DEVELOPMENT HEARING OFFICER

PR-2023-008674

SD-2024-00056 – PRELIMINARY

REQUEST: SUBDIVISION OF LAND - PRELIMINARY PLAT FOR PLAYA DEL SUR

Sheet 4 of 5
230681

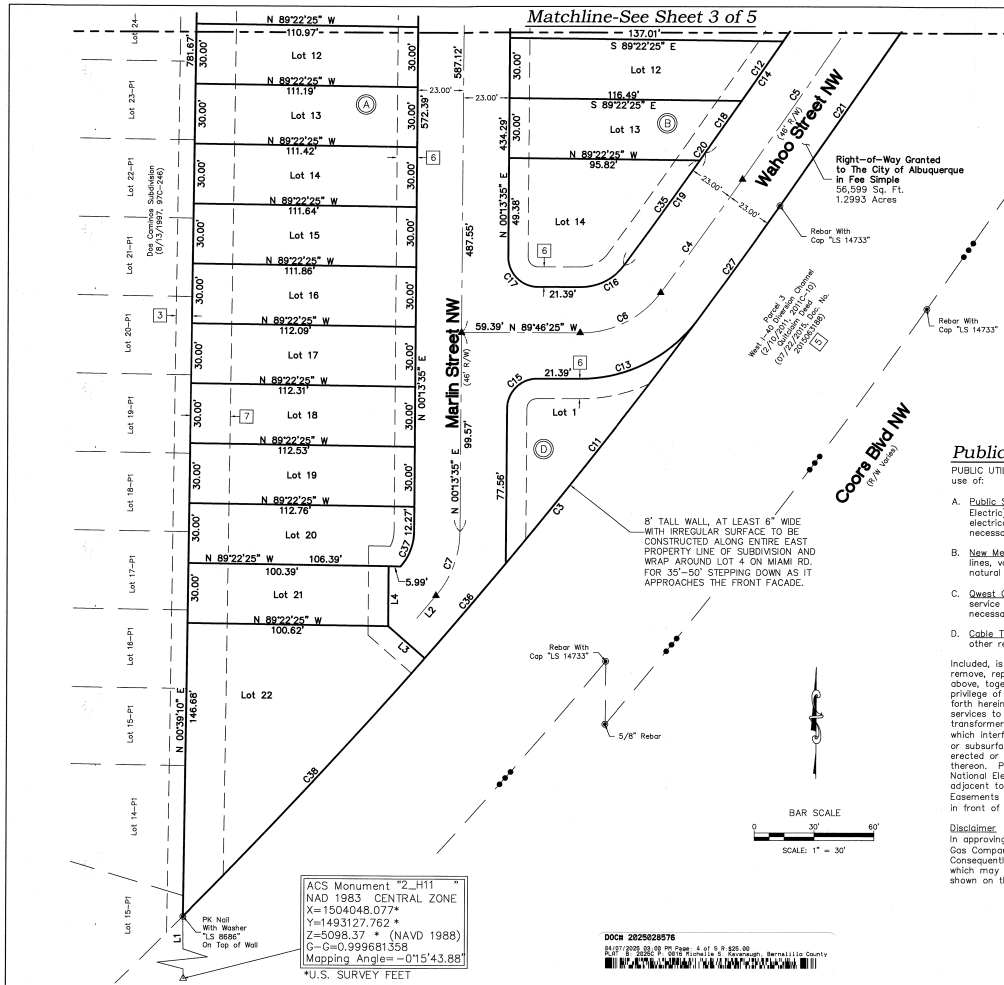
1. Availability Statement 230531 has been executed and provides conditions for service.
2. Infrastructure List:
 - a. 8-inch sanitary sewer infrastructure is not required along Miami Rd. (delete)

- b. 8-inch water and sanitary sewer lines along Marlin St. needs to extend up to lot 21 and 22... however this can be elaborated.
 - c. ¾" services can be removed since all waterlines and sewer lines include services... is there a reason for the specific line item for services?
